July 24, 2018

Re: MMC Staff Parking Garage | 222 St. John Street | Level III Site Plan  
Response to Public Comments

CONTECH JELLYFISH FILTER DETAIL
N.T.S.

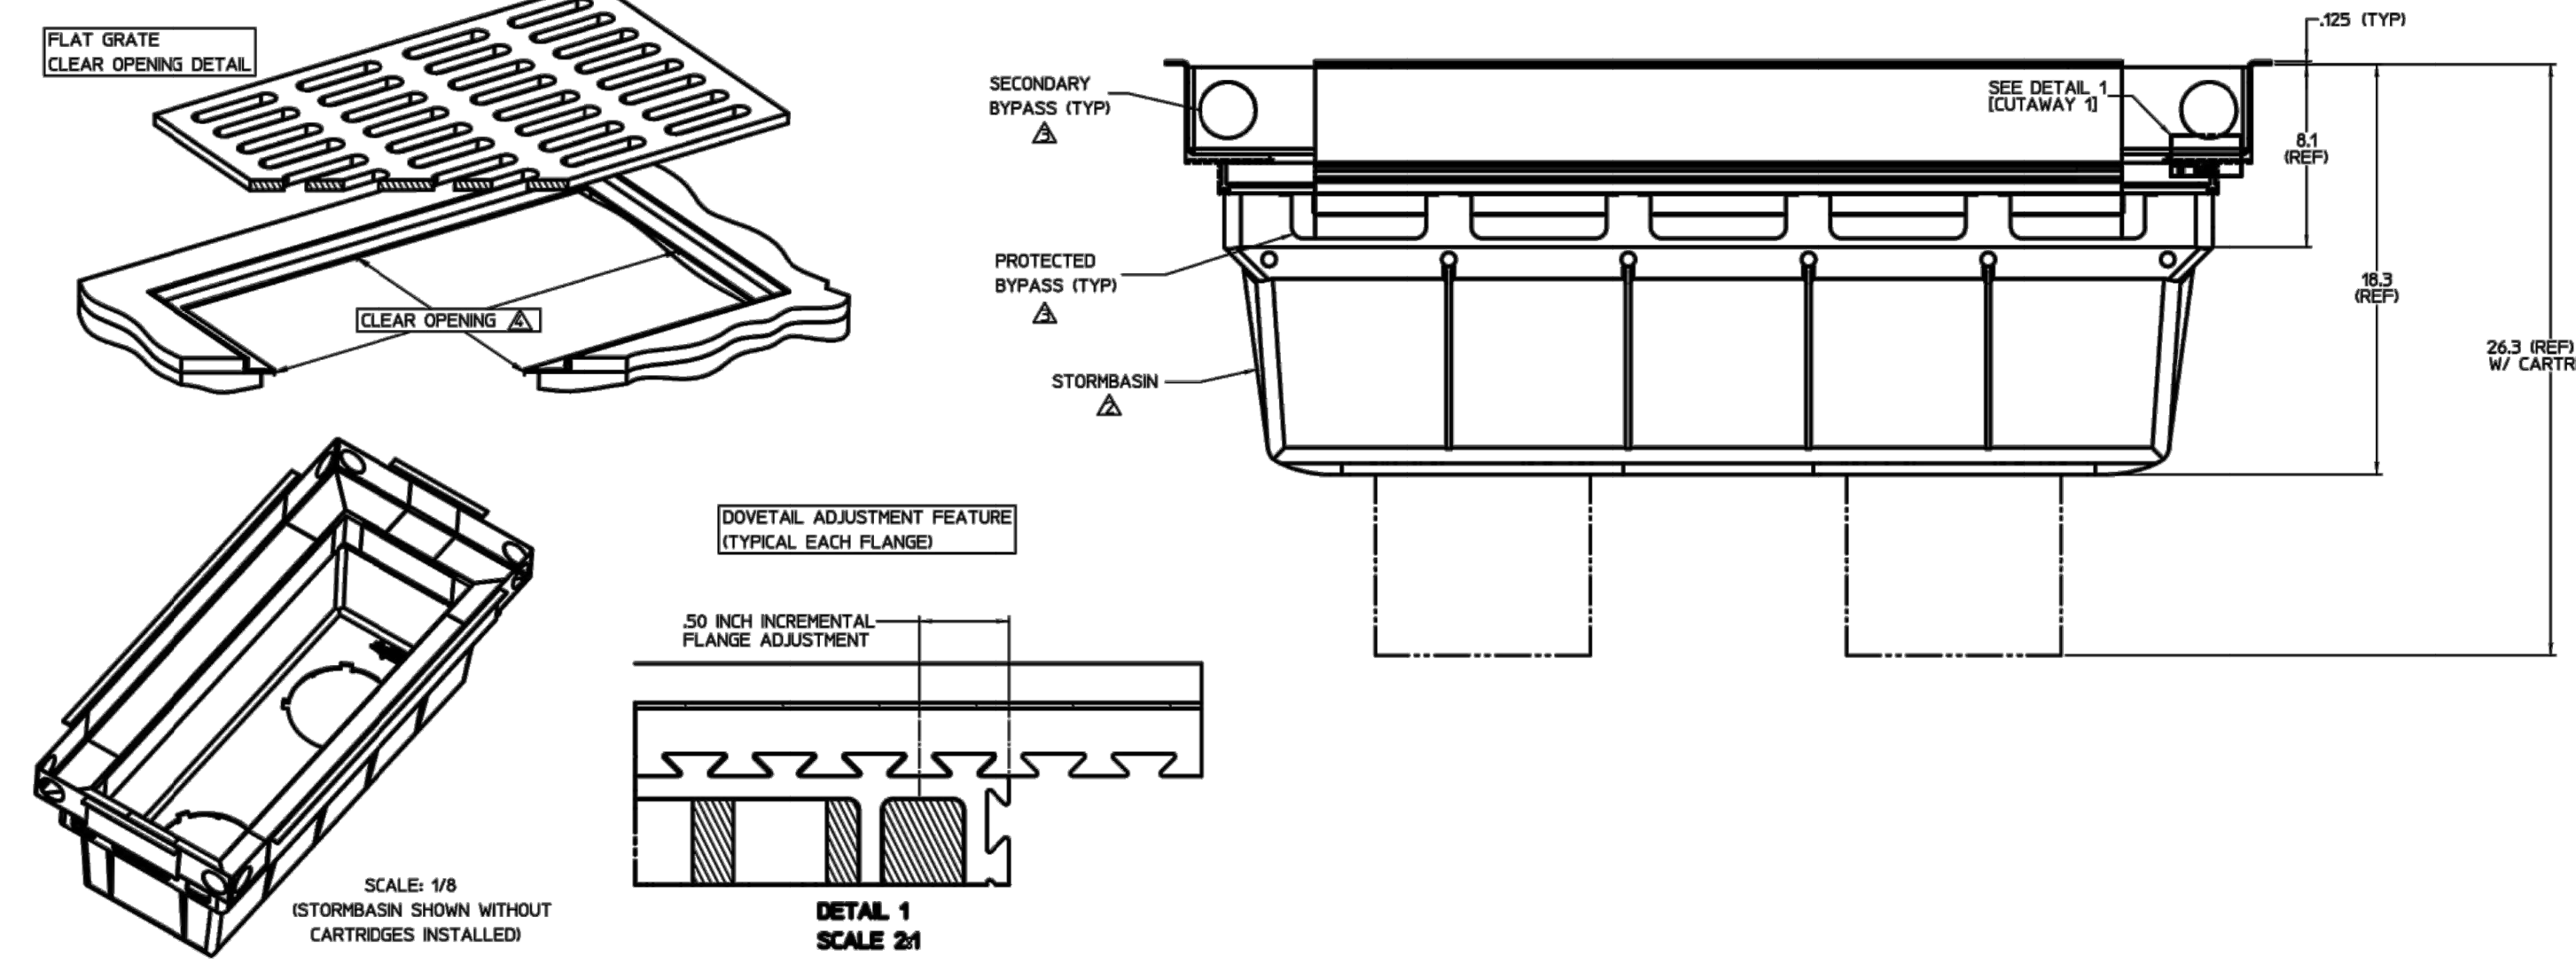
b. *Additional data/detailing is needed to confirm that the R-Tank system and Jellyfish Filter are designed in consonance with the HydroCAD model.*

d. *Pipe 22 has 0.0% slope. Confirm this is the intended design or if the pipe should be sloped to the JellyFish Filter.*

**Response:** Pond 1P within the HydroCAD model utilizes information provided by both ACF Environmental and Contech. ACF Environmental provided a HydroCAD node for the R-Tank storage volume, and Contech Provided a HydroCAD node with the appropriate outlet information to ensure that flows routed to the Jellyfish Filter will meet the required cartridge flow rate design criteria.

**Response:** Pipe 22 was designed with a 0.0% slope to the Jellyfish filter per Contech recommendations.
